**RE: G&S Meats**  
**1333 Aspen Ave NW**  
**Grading and Drainage Plan**  
**Engineer's Stamp Date: 02/09/24**  
**Hydrology File: H13D119**

Based upon the information provided in your submittal received 02/09/2024, the Grading & Drainage Plan **is not** approved for Building Permit. The following comments need to be addressed for approval of the above referenced project:

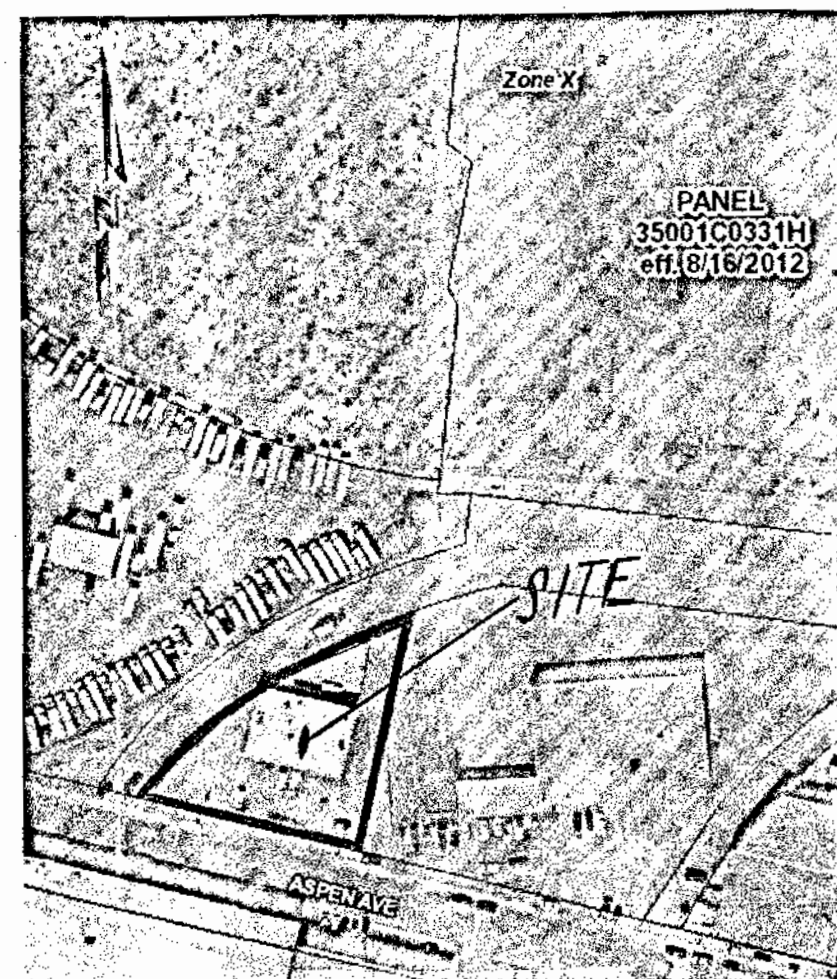
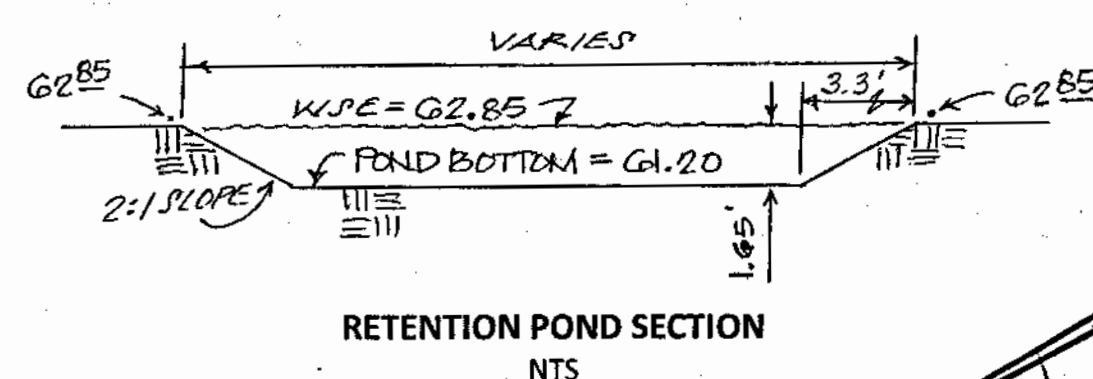
1. The drainage runoff for the proposed addition drains toward the northeast corner of the property. Therefore, this needs to be in a retention pond that holds the 100 year – 10 day volume for this addition only. Please provide the calculations and show that the retention pond can be placed in this limited space. If not, then the addition may have to be reduced in order to handle both the proposed addition and the required retention pond.
